Appeal Decision

Decision date: 15th July 2022

Appeal Ref: APP/R5510/W/22/3295033

61 Long Lane, Ickenham, UXBRIDGE, UB10 8QU

FIGURE 4: SHOWING PROPOSED DEDICATED REPLACEMENT BAT LOFT.

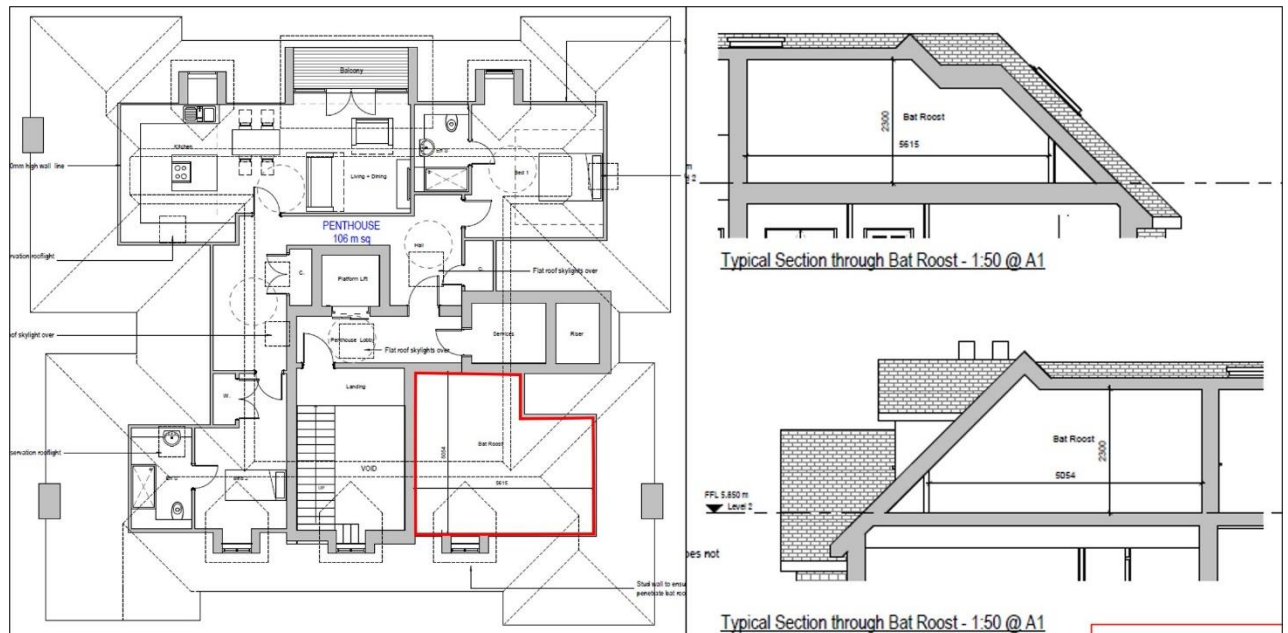
17. No mitigation measures have been put forward as part of the scheme and so I cannot be assured that the development could be designed to protect bats during the construction phase or that long term impacts upon the local bat population could be mitigated. Therefore, I must conclude that the proposal as submitted would cause harm to protected species and their habitats, contrary to Policy DMEI 7 of the Local Plan and Policy G6 of the London Plan and the Framework which have similar aims.

Proposed Front Elevation - 1:100 @ A1

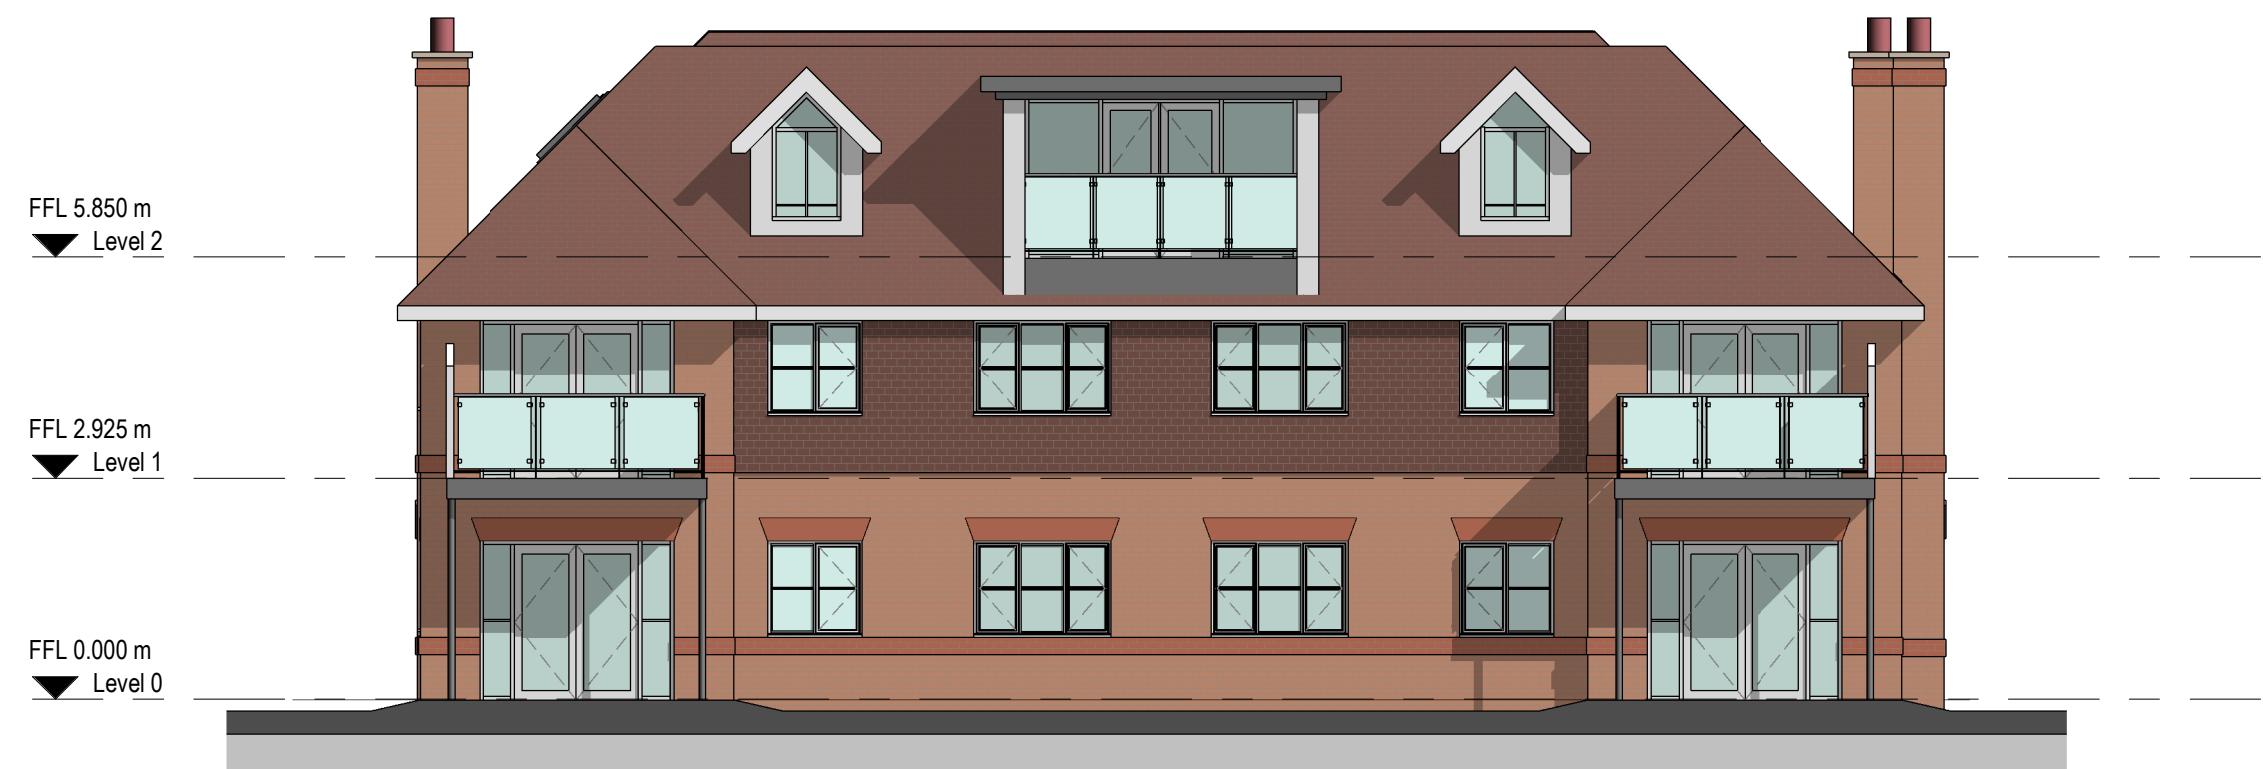
5. The appeal relates to the erection of a significantly larger building on the site which would provide 9 apartments. Although plans show that the building would not be significantly higher than the existing dwelling, it would be wider and substantially deeper, and would include a "crown" roof. This would facilitate an additional storey of development within the roof space. As a result, and in comparison, with the existing structure, which has a steep roof sloping to ground floor, the proposed building would appear much larger in comparison.

6. Furthermore, although the design of the proposed building includes references to the original in the form of dormer windows, high chimneys and timber boarding, it would have limited variation in depth along the building frontage. Despite being set marginally further back on the plot, this lack of articulation and the significant mass of the structure would result in an intrusively bulky building, which would lack much of the refined detailing that characterises the more attractive buildings in the wider street scene.

7. I take account of the fact that the wider area includes a variety of architectural styles, including some flatted development, not all of which make a positive contribution to the Conservation Area. I also note that the more contemporary elements of the design would be to rear, and so not visible in the street scene. Nevertheless, although relatively well screened, the significantly wider and deeper building would be clearly evident in views into the site from Long Lane. In these views the bulk of the building would result in it appearing obtrusively out of scale with the more domestic scale of other dwellings in the street scene. It would also erode the sense of spaciousness which currently contributes to the character of the conservation area.
